The following information is provided in response to the public and agency queries raised during the course of the SSDA Exhibition.

McConnel Smith & Johnson

The detailed masterplan was prepared for Bowral & District Hospital to illustrate how the proposed building has been designed and located to integrate with existing buildings and support future hospital development.

Main Entry and Carpark

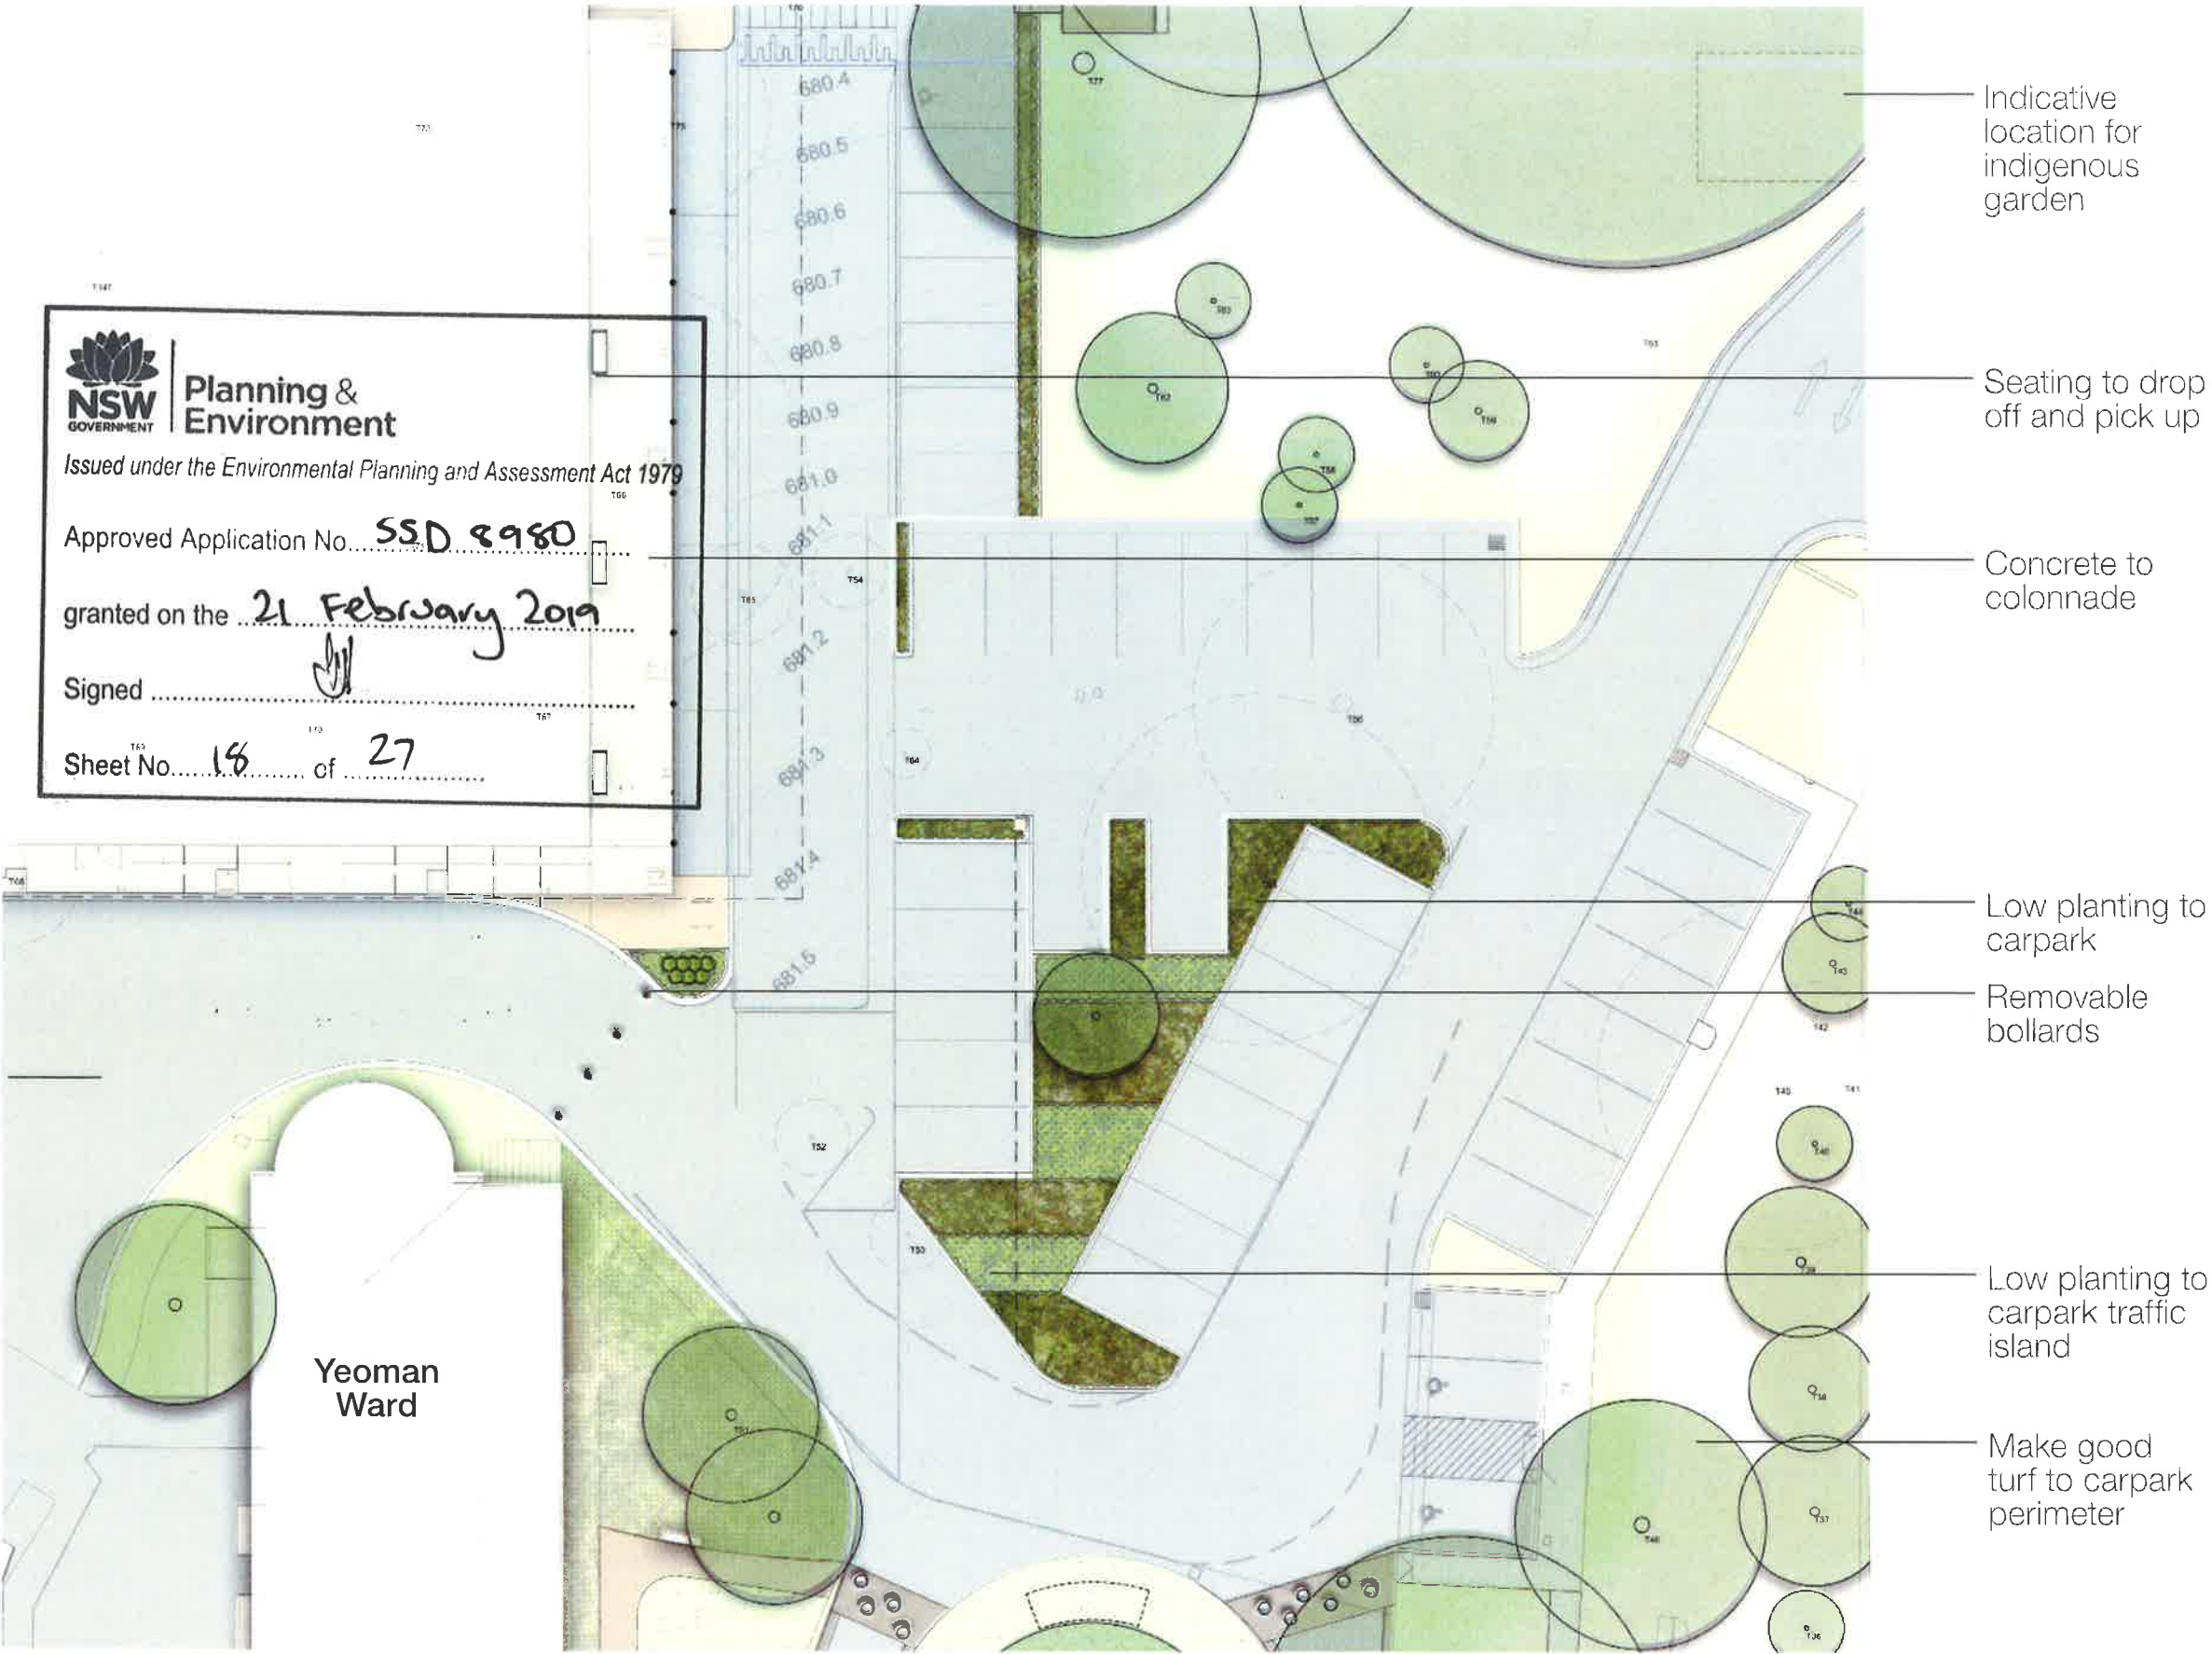
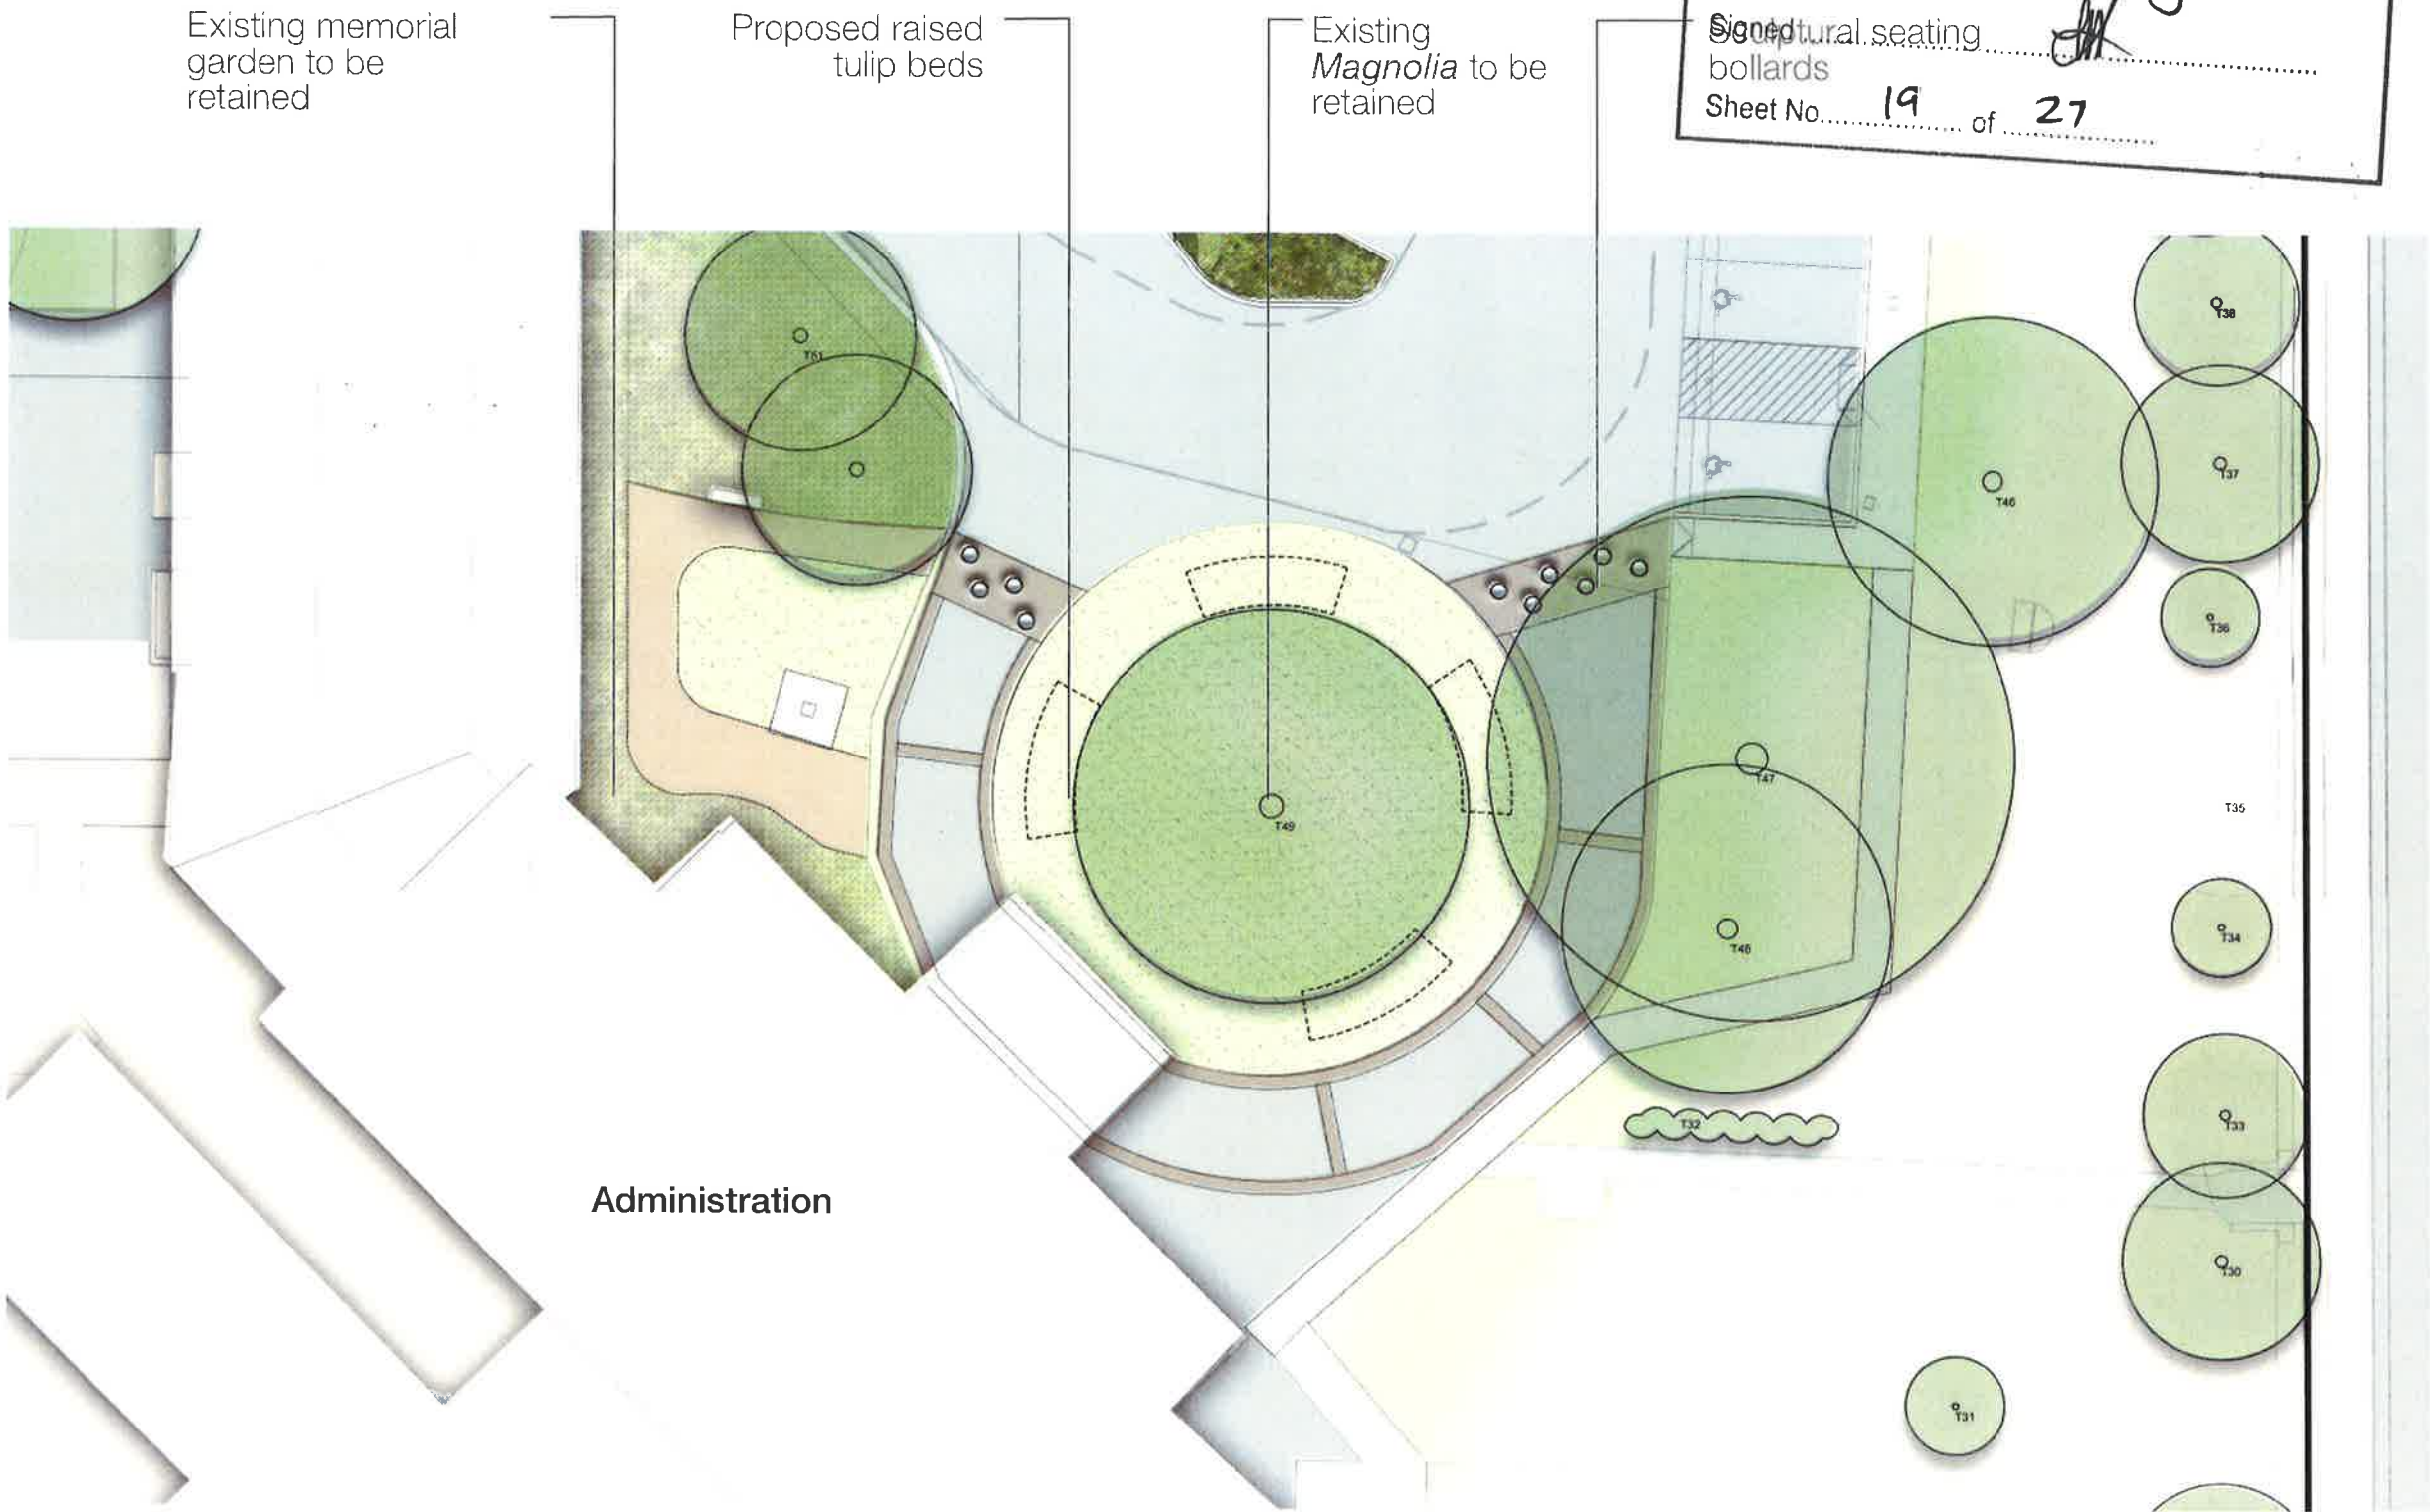
3. ENTRY, SITE CONNECTIONS & LANDSCAPING

The site works and landscape have been developed to address public access and amenity with the following elements:

- a shared pedestrian zone/wombat crossing to improve public access to the existing culturally significant area of landscaping.

- the development of a timber deck seating area in the landscape opposite the main entry accessed via the shared crossing area.

- public seating is located along the colonnade area along the main drop off area and main entry

Details of these areas can be seen in the Appendix 3 Landscape DD Report

SITE PLAN - DD CONCEPT

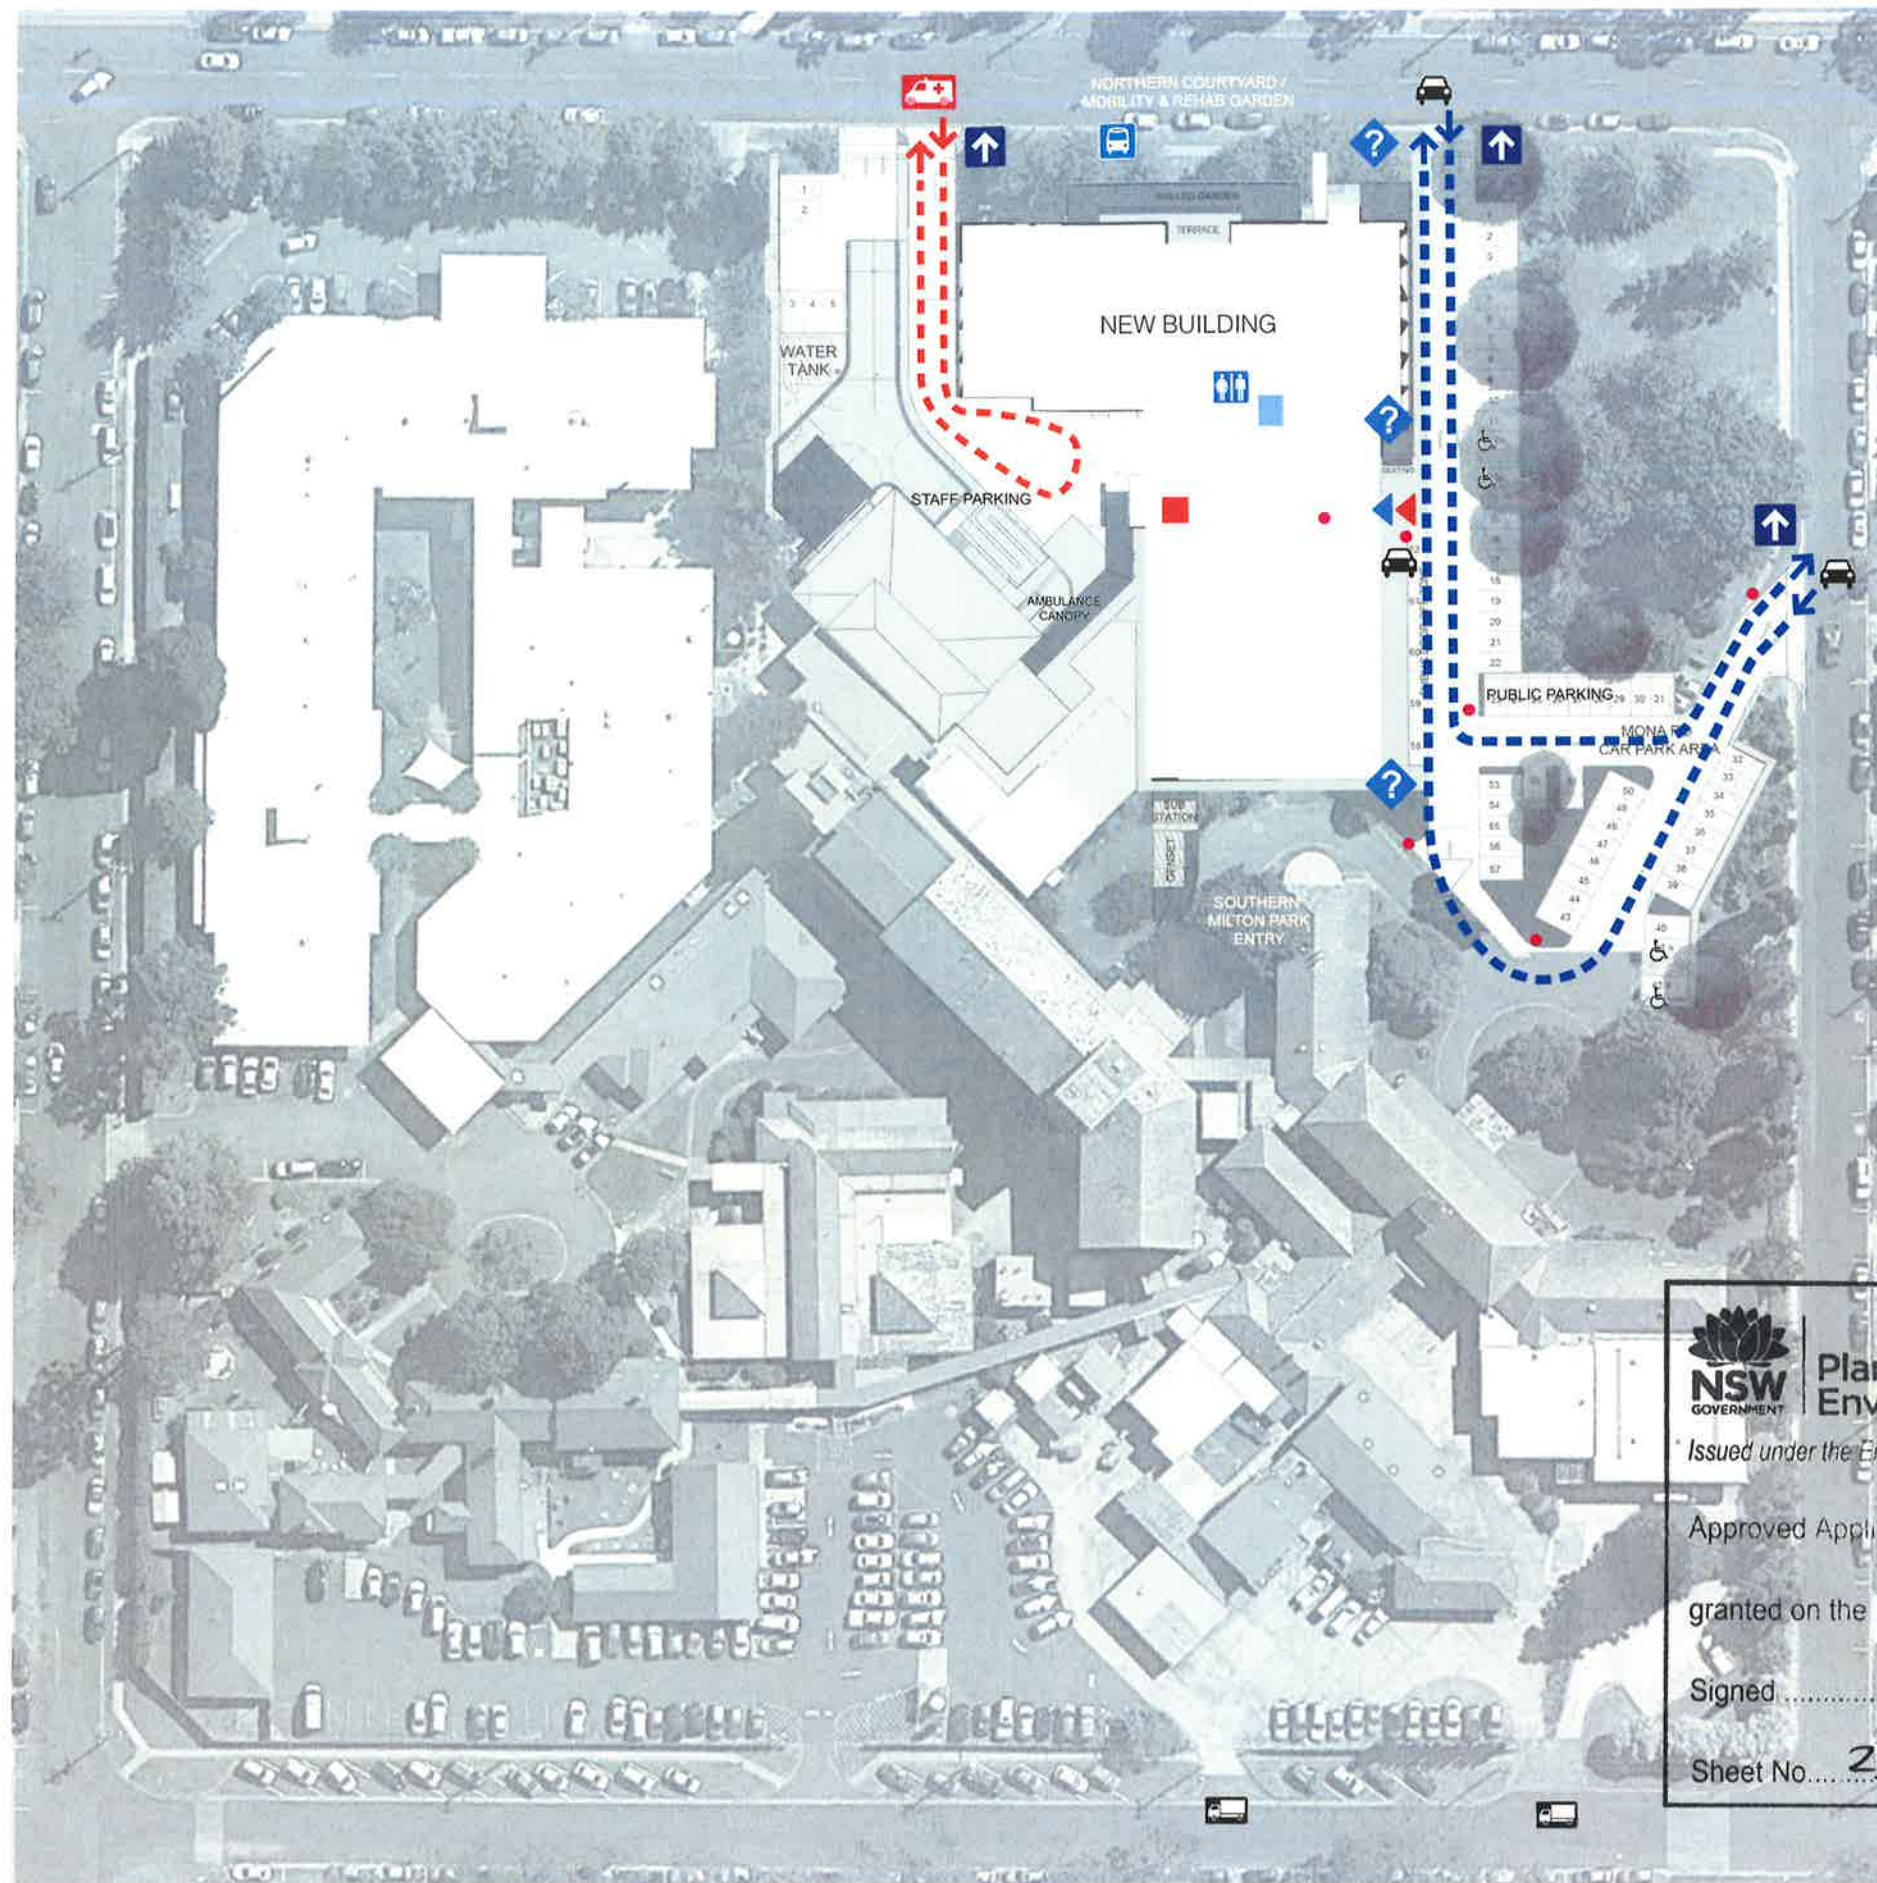
1. TFNSW

The implementation of wayfinding strategies including safe marked walkways in the proposed carpark improvements is being developed and will continue to be refined through the documentation process.

Wayfinding strategies have been developed to provide safer marked walkways and shared areas within the proposed car park improvements. An outline of these proposals can be seen Appendix 1: Site Plan DD Concept with additional details contained in the Landscape and Wayfinding Reports Appendices.

An outdoor area has been identified to be developed in consultation with the local Aboriginal community. The area identified can be seen on the DD Concept Site Plan & Landscape Report.
